PLOT 5000, HATFIELD BUSINESS PARK

Reference: 6/2017/0624/MAJ

OBJECTIONS:

drawing  
**Proposed Site Layout Plan**

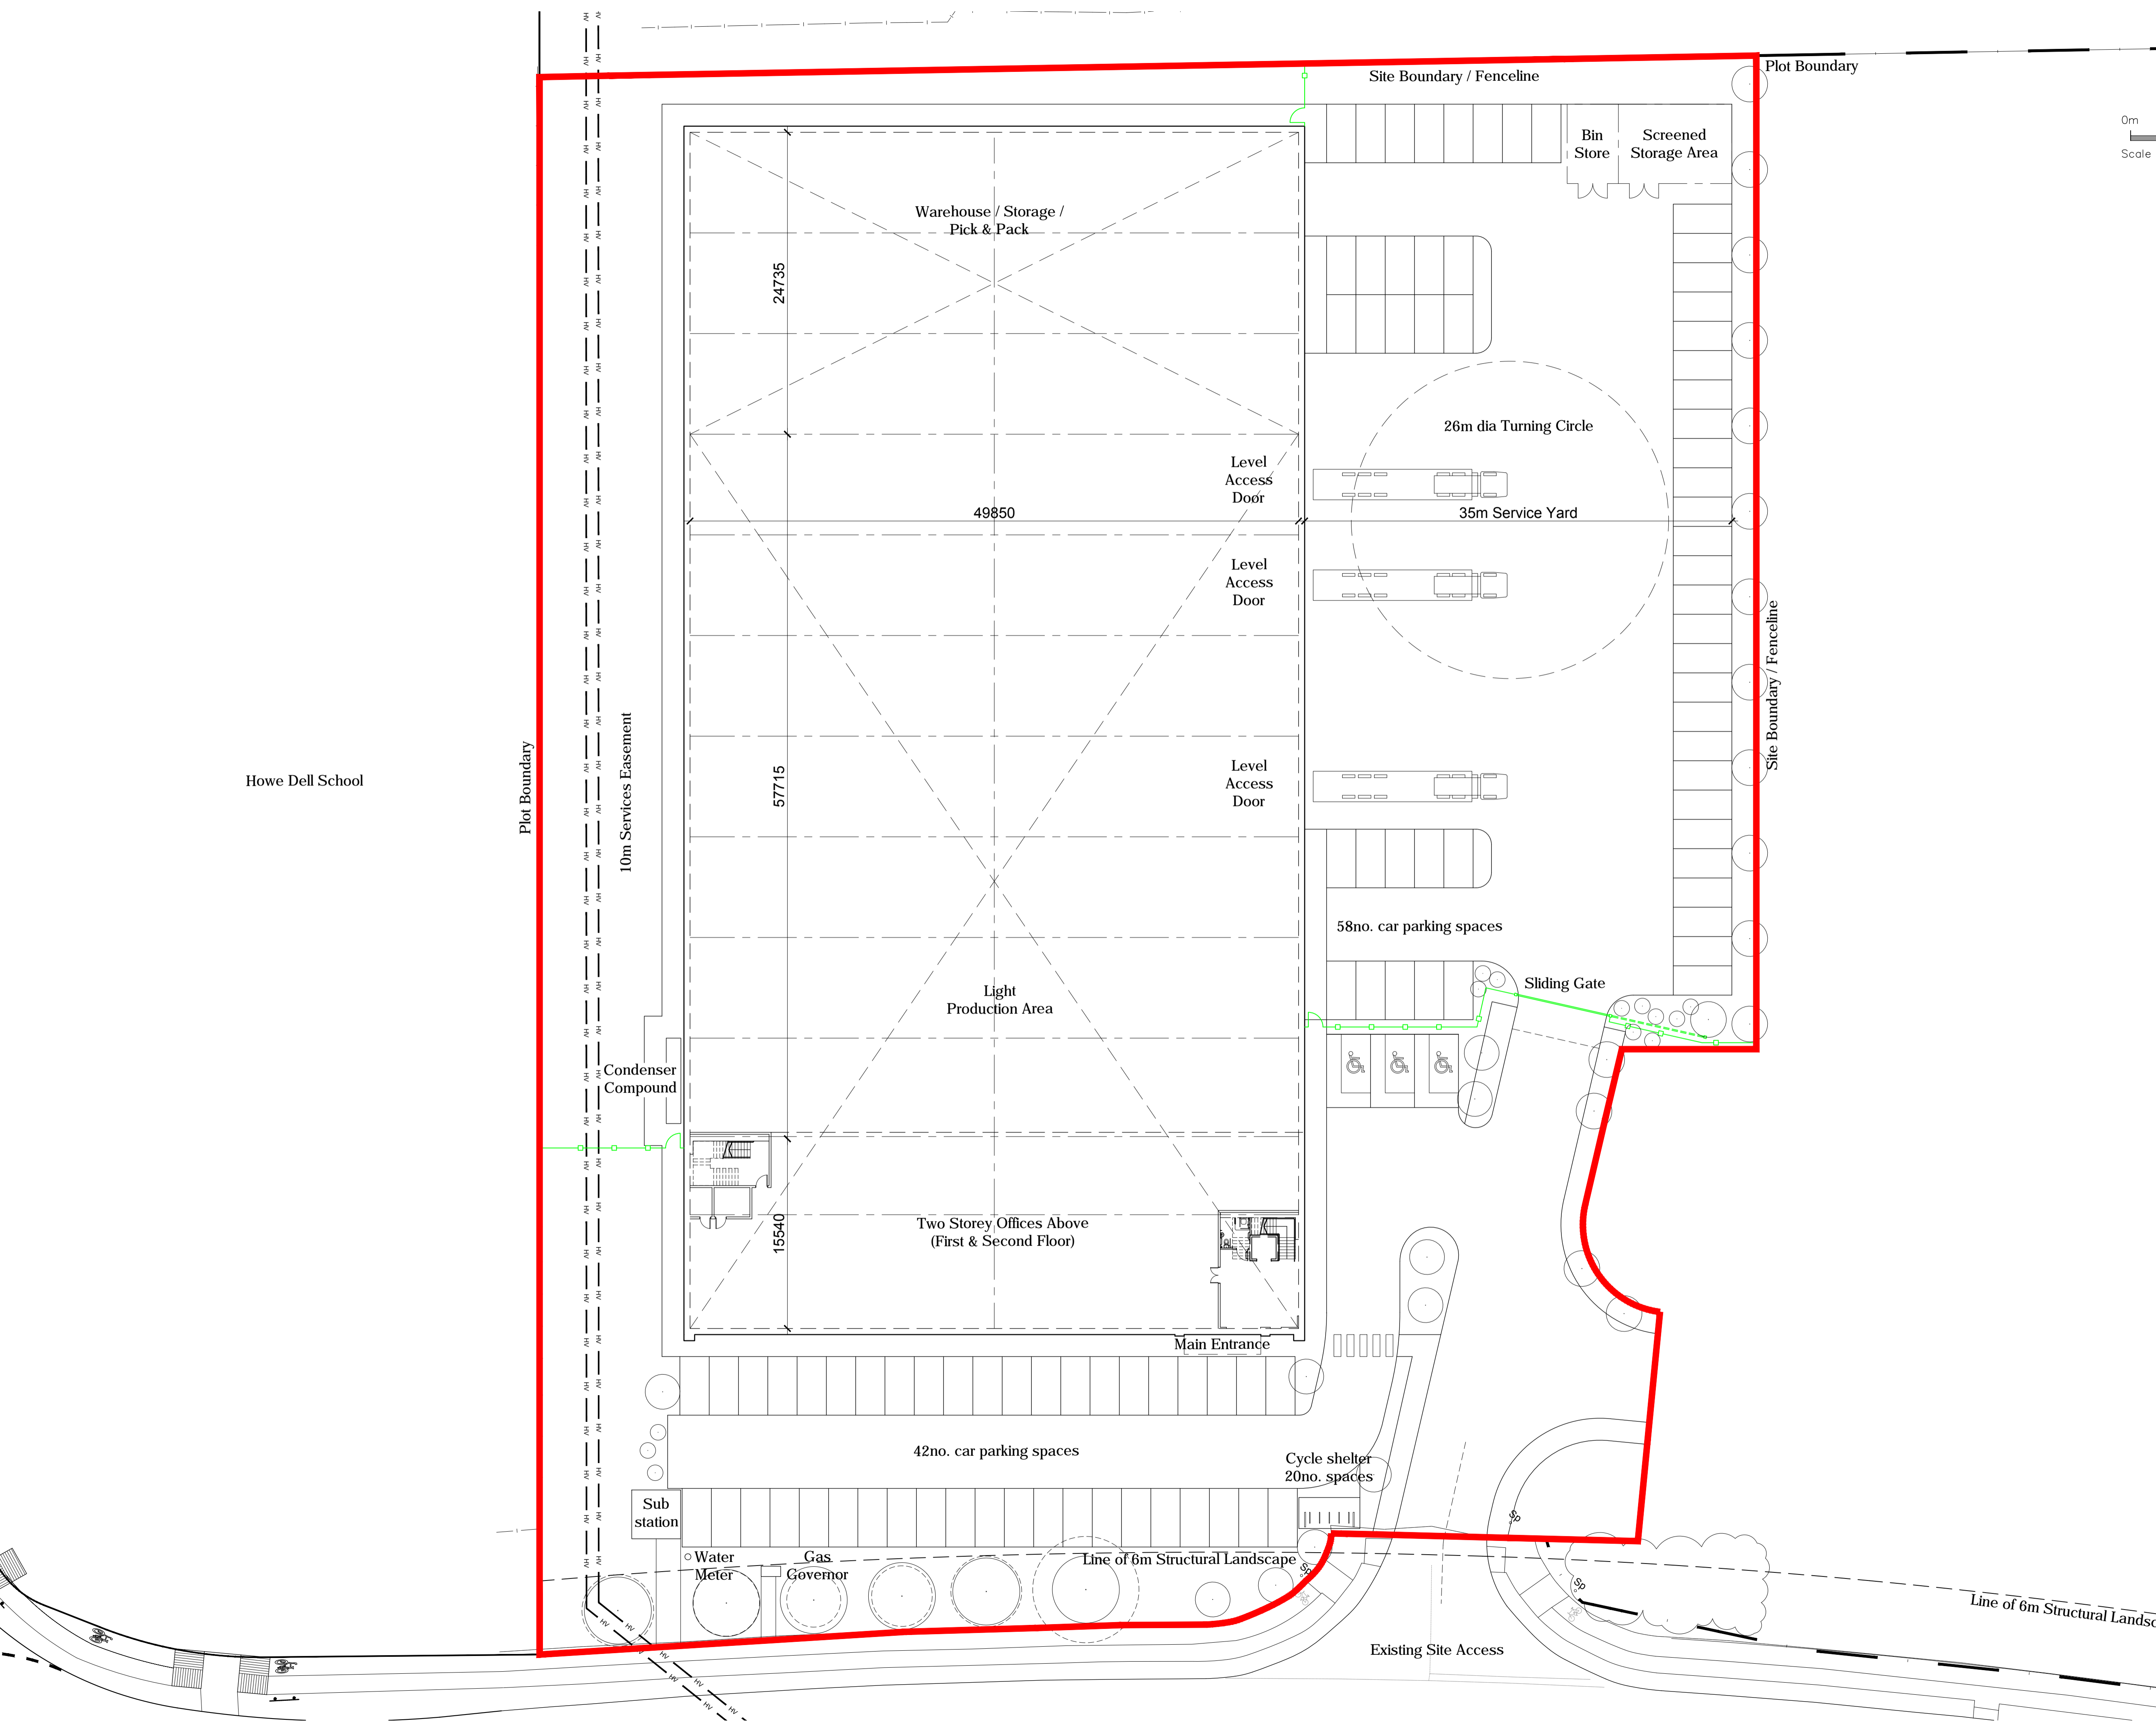
1. My main reason for this is that it does not seem to take account of the fact that its south west boundary adjoins a residential area which forms part of the Business Park. The concept of the Business Park was to bring together residential, office and industrial use to complement each other and as far as possible to be in keeping with and to take account of these very different usages and design specifications. This is most important when the usages differ on development sites that share a common boundary, as they do in this proposal. Consideration is needed, in my view, to blend or soften the impact of the very different usages to ensure the developments are in keeping with each other and do not have a negative effect by transforming the amenity of existing developed areas. This is usually achieved by taking into consideration the scale, i.e. height and length, of the buildings and also by extensive landscaping. None of these issues seem to have been taken into consideration as regards this proposal. This is especially the case on this south west shared boundary. The proposed development seems to aim to be the largest in terms of height and length and to be as close as possible to the boundary with virtually no landscaping, so it will be the most obtrusive it can be and have the greatest negative impact on the adjoining residential and school developments.

2. The access to this proposed development is close to an already busy roundabout which is the main access to this prime residential area of the Business Park and is also a bus route. This roundabout is already very congested at rush hours and school drop and pick up times and the additional 40+ commercial vehicles and up to 100 staff cars needing access to the new development are bound to cause additional congestion. This will result in increased traffic delays as well as increased noise and air pollution, certainly not a good outcome so close to a primary school that is I understand a flagship eco-school for Hertfordshire.

I would consider what would be more appropriate is warehousing and office usage but on a smaller scale with well thought out to include landscaping – embankments, fences, trees shrubs etc. along the south west boundary and traffic accessing the site further away from the present roundabout, even perhaps to the same access as the IO Centre.
